**RE: Request for Further Information
Lingard Private Hospital Expansion (SSD-60316710)**

This letter is submitted to the Department of Department of Planning, Housing and Infrastructure in response to the Request for Further Information (RFI) issued on 10 December 2024, relating to SSD-60316710 for the proposed expansion of the Lingard Private Hospital.

1 21 JUNE 1PM
Scale 1 : 500

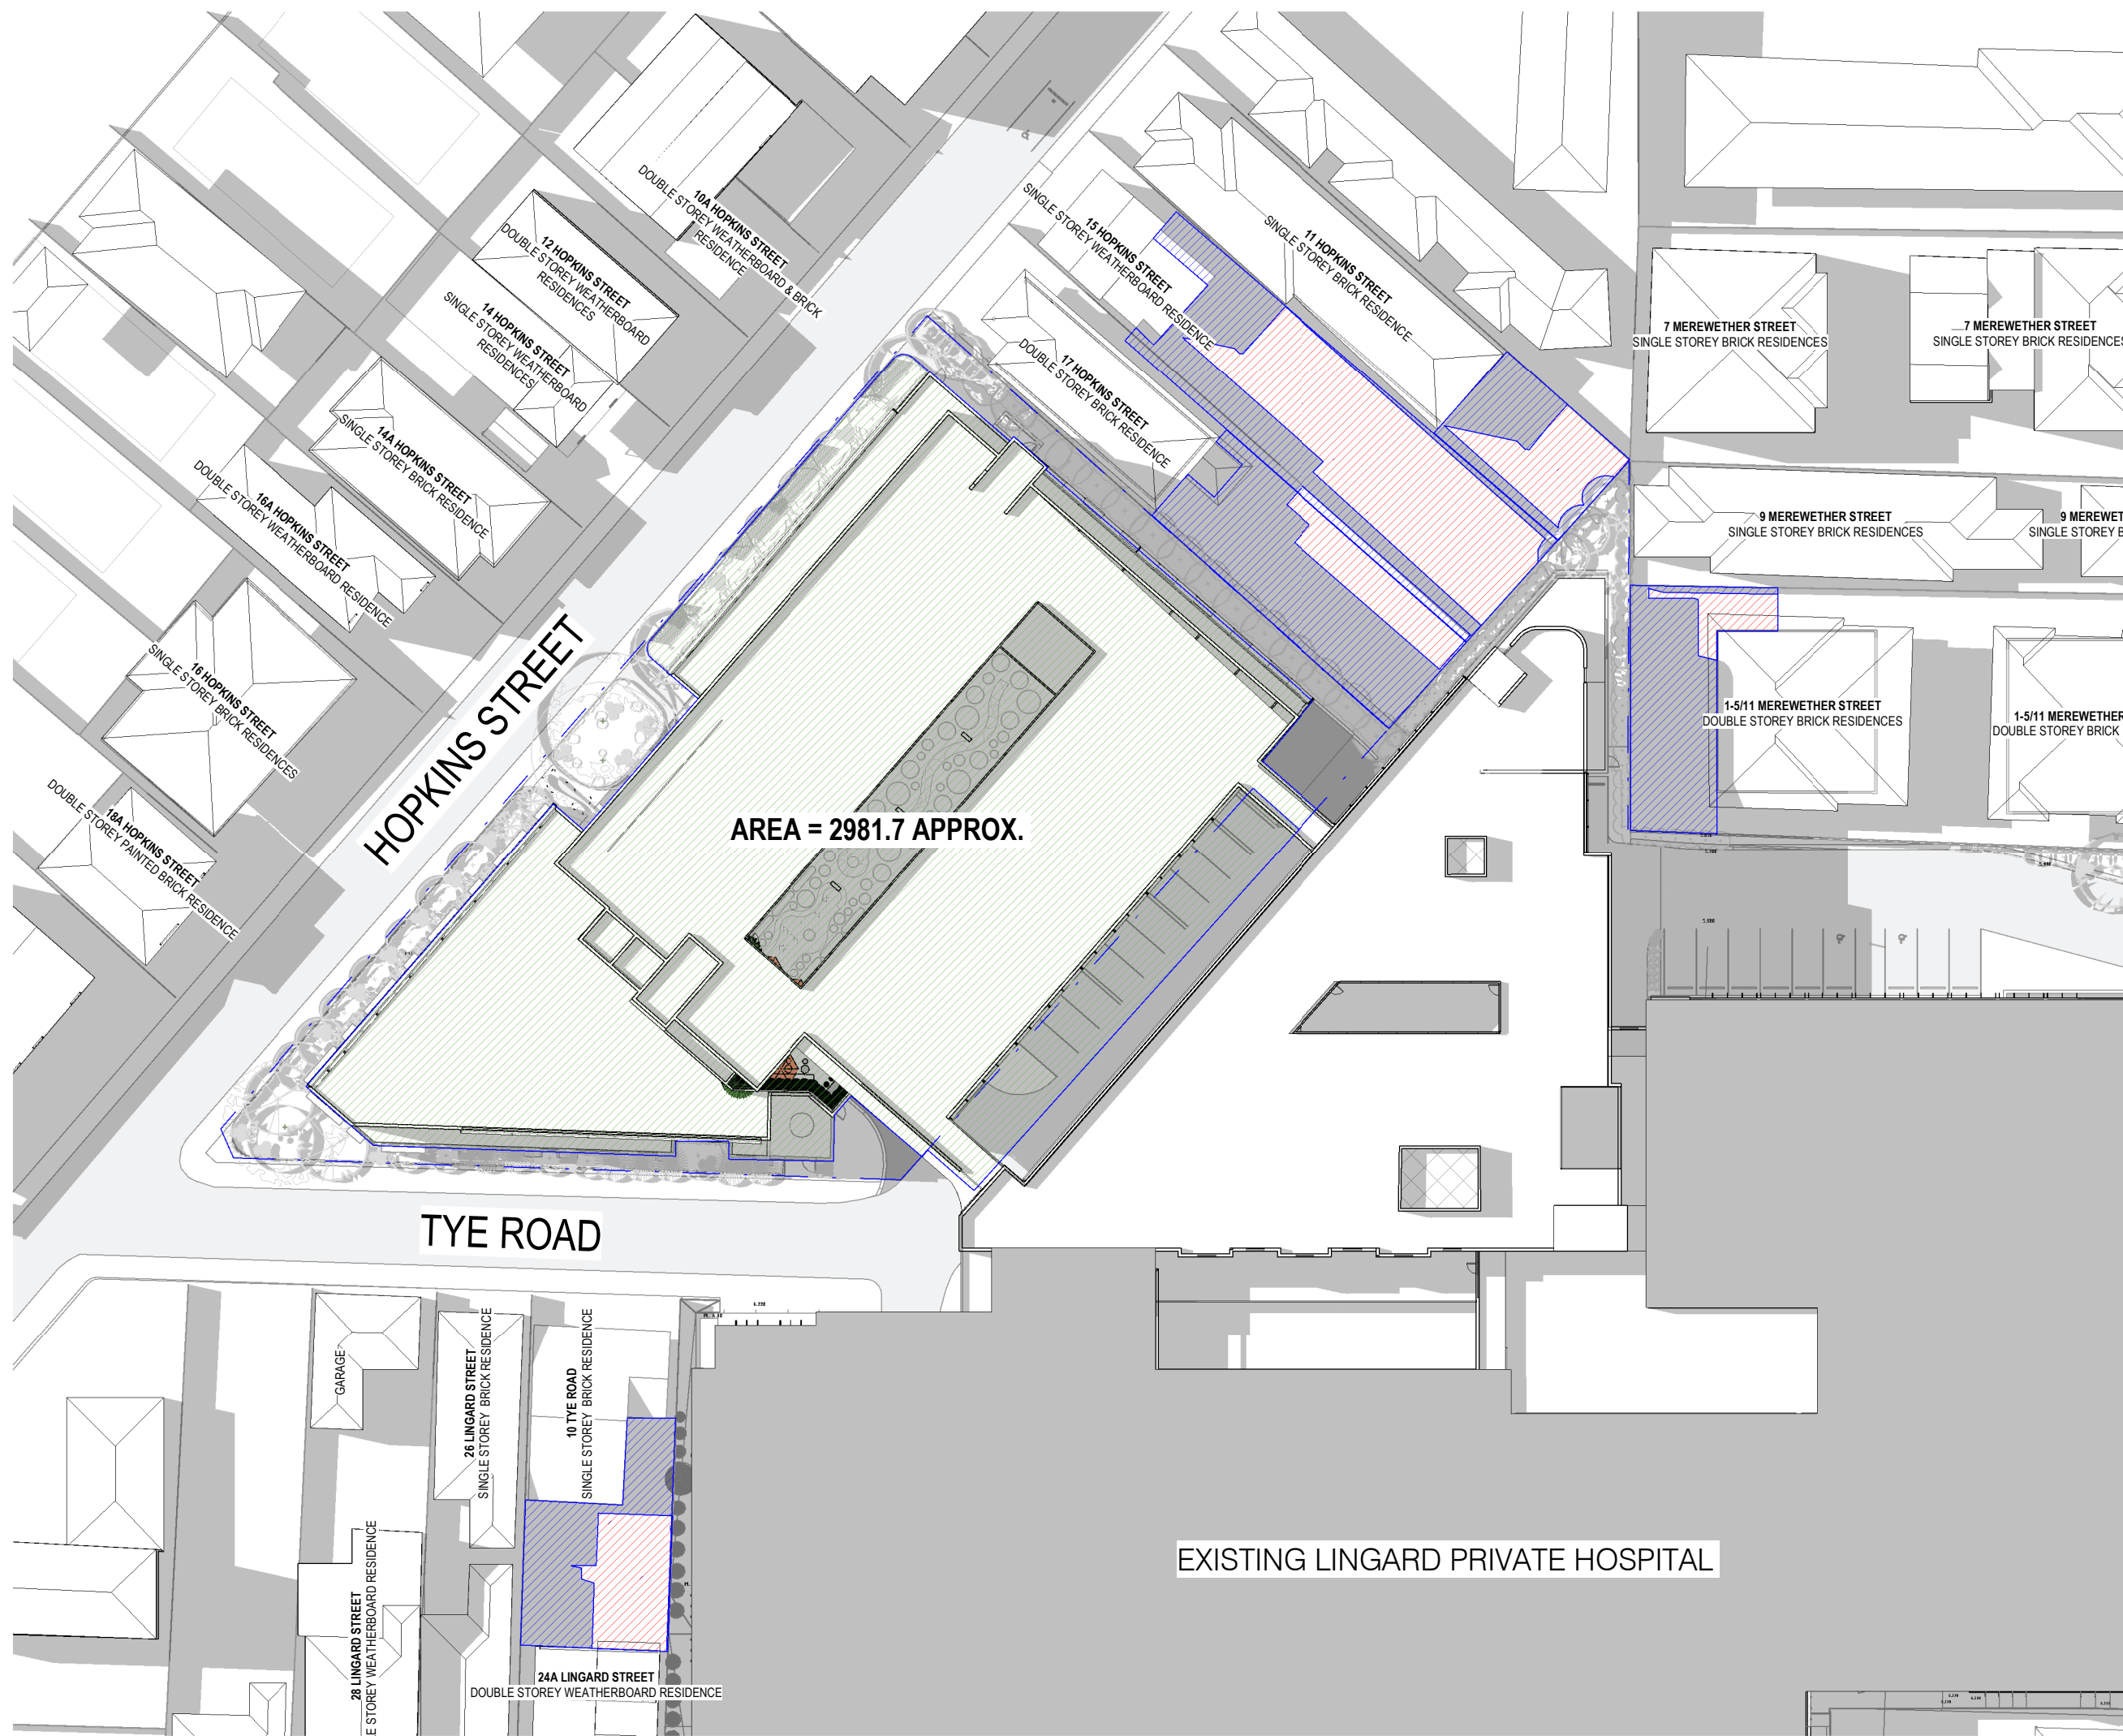
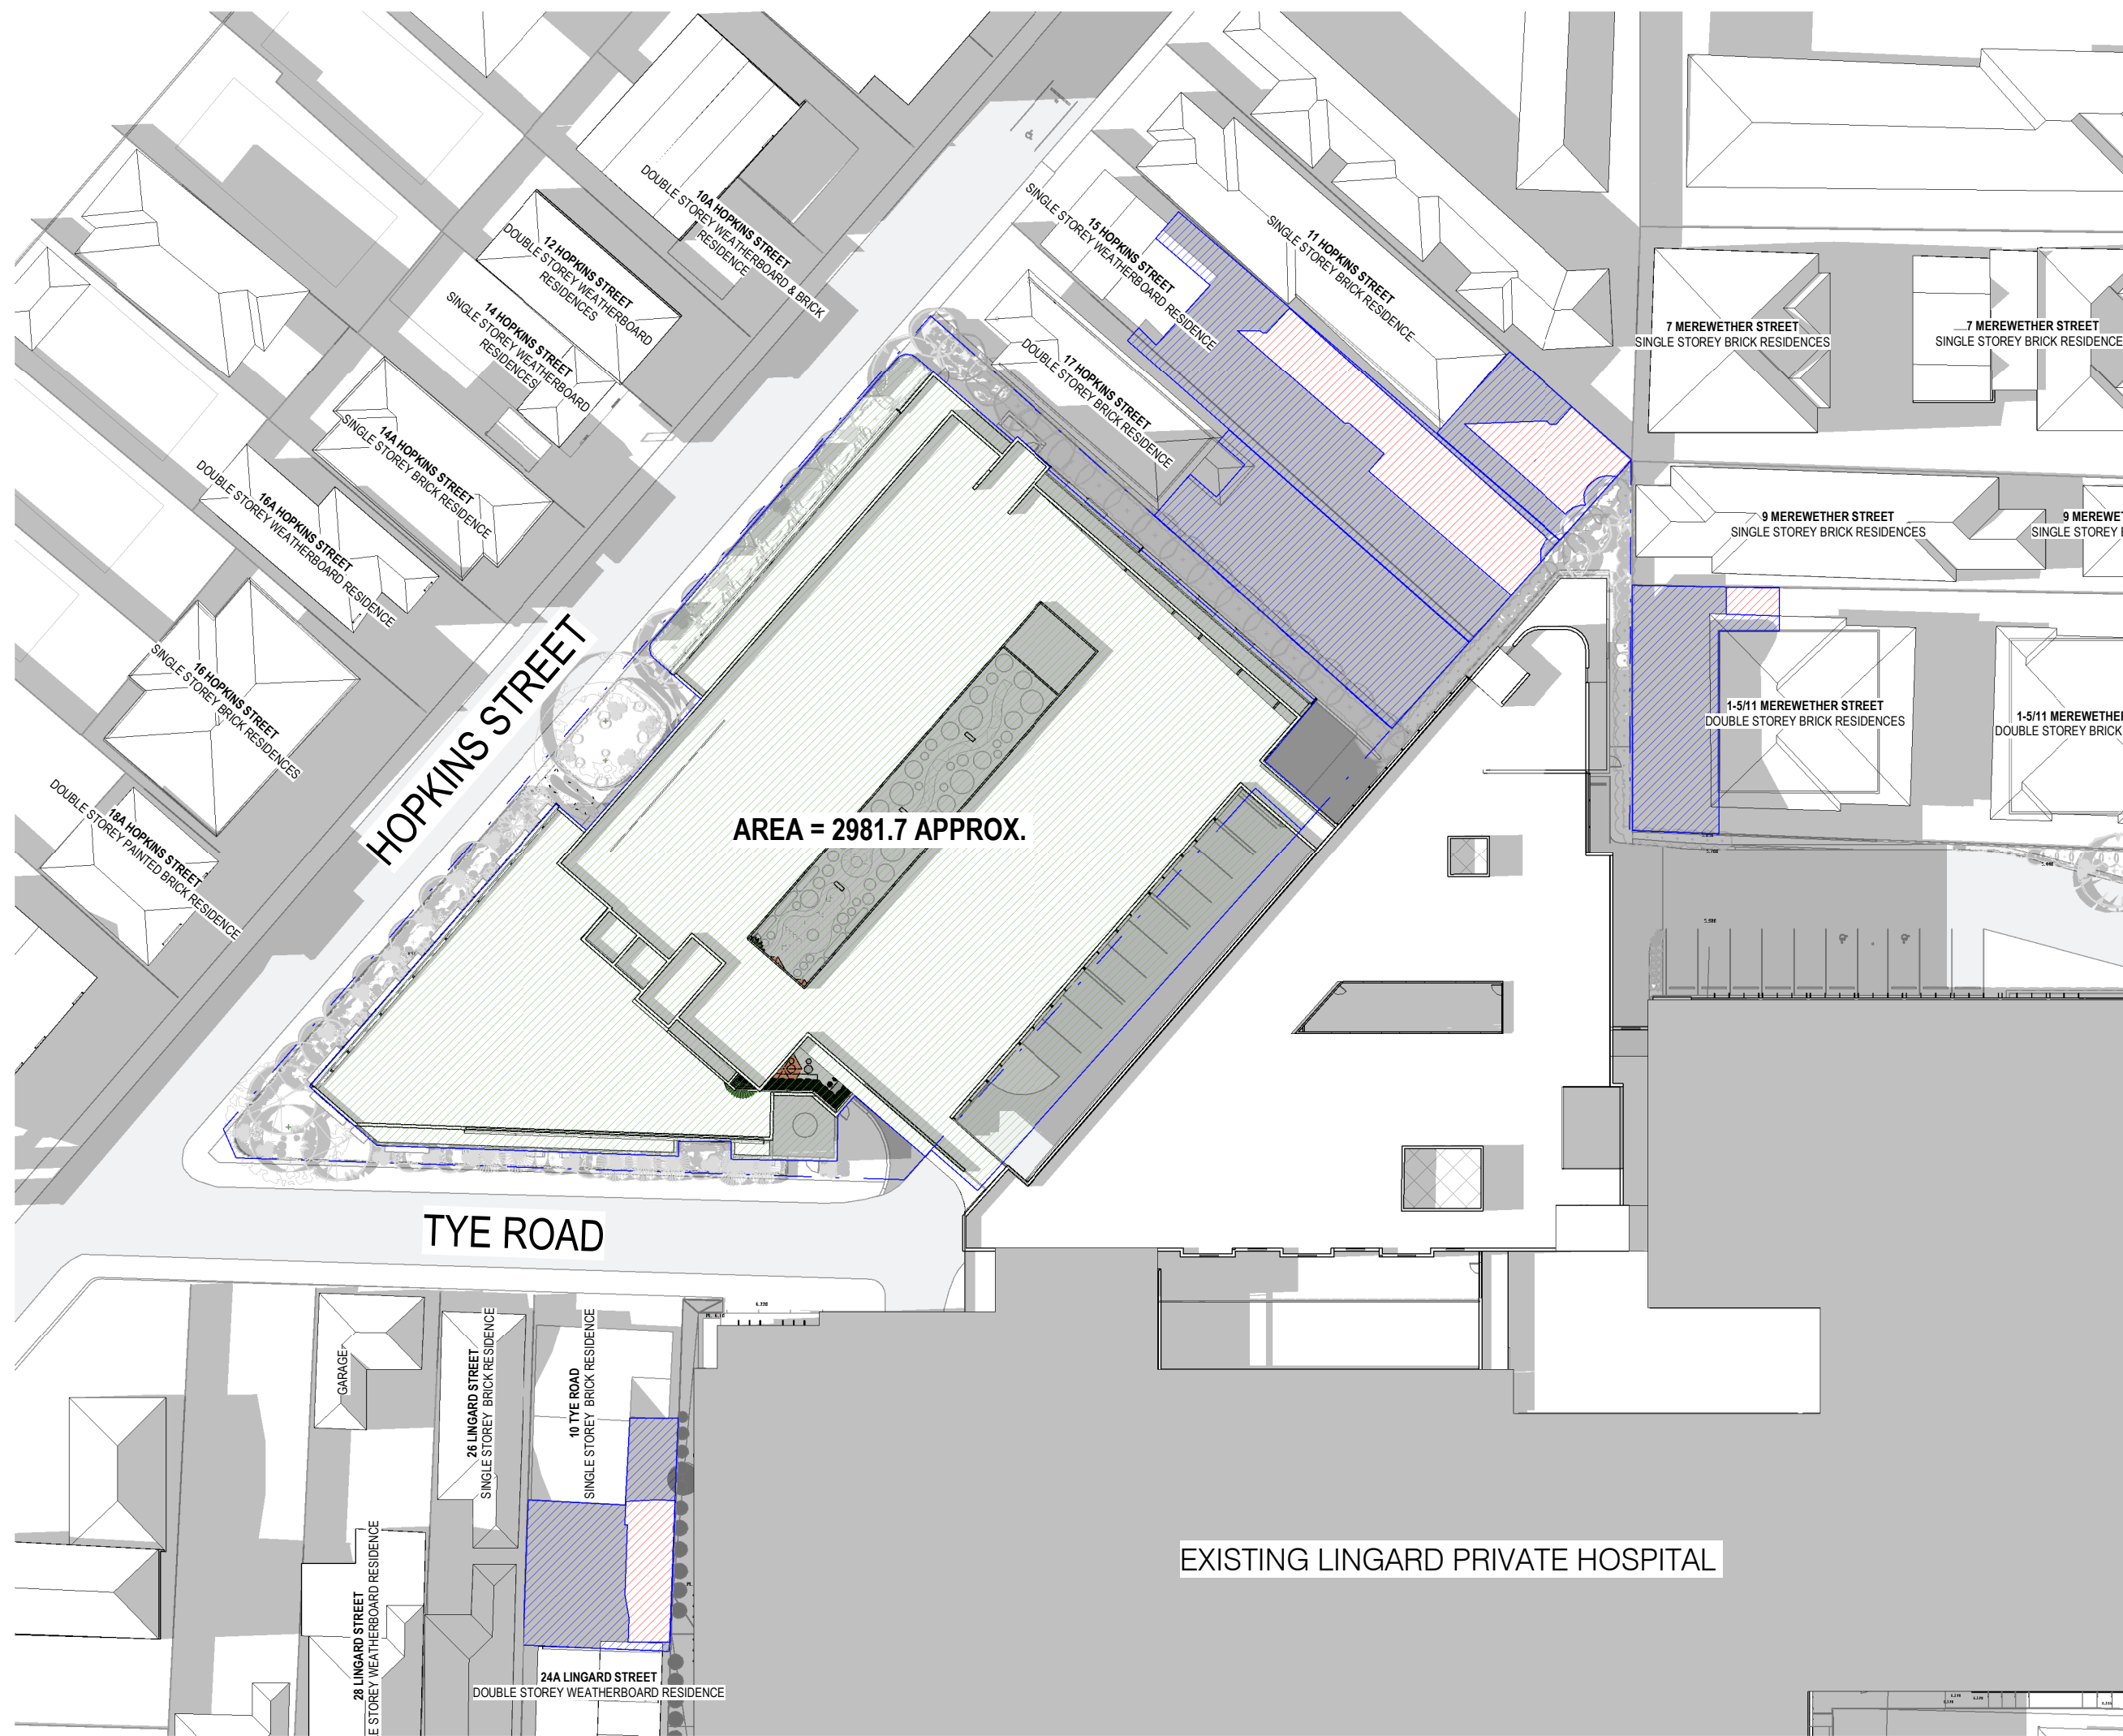
CN's concerns regarding residential amenity remain. The amended architectural plans do not include hourly shadow diagrams or 3D shadow analysis to identify the habitable rooms and private open space of residential properties, as previously requested. The shadow impact to Mitchell Park has not been adequately addressed.

The non-compliant height coupled with reduced setbacks on the eastern boundary of the Hopkins Precinct, exacerbate the amenity impacts. CN recommends the design is amended to reduce the bulk and ensure upper floor levels comply with the setback requirements and maximum building height development standard. CN recommends the applicant is required to submit additional shadow diagrams at hour intervals between 9am and 3pm during the June 21 winter solstice.

Additional shadow diagrams have been provided at Appendix A. The overshadowing of Mitchell Park is minimal, occurring only at 9 AM during winter. The affected area consists of large trees and on-street parking that would naturally be in shadow. The proposal ensures ample daylight reaches the trees and surrounding area at all other times.

The amended shadow diagrams include percentage calculations for the surrounding residential dwellings and confirm compliance. The most significant impact is on 11 Merewether Street in the afternoon; however, the existing shadow diagrams show that this is also the present state, refer to Figure 1 & 2 below. In the previous iteration of plans the second level wall was also setback further from this boundary.

The proposal does affect the adjoining Hopkins Street dwellings at 3 PM; however, there is no impact during the morning hours. The proposed setbacks are consistent with the existing dwelling setbacks in the area. While there is some overshadowing in the afternoon, the dwellings receive sufficient sunlight in the morning,

Overall, the proposed height variation does not result in any unreasonable adverse impacts on neighbouring properties in terms of bulk, scale, overshadowing, or privacy. The minor exceedance is justified by the functional necessity of the affected building elements and their limited contribution to the overall form, ensuring a well-balanced outcome that meets the intent of the planning controls while supporting high-quality urban design. Additional shadow diagrams are provided at Appendix A.
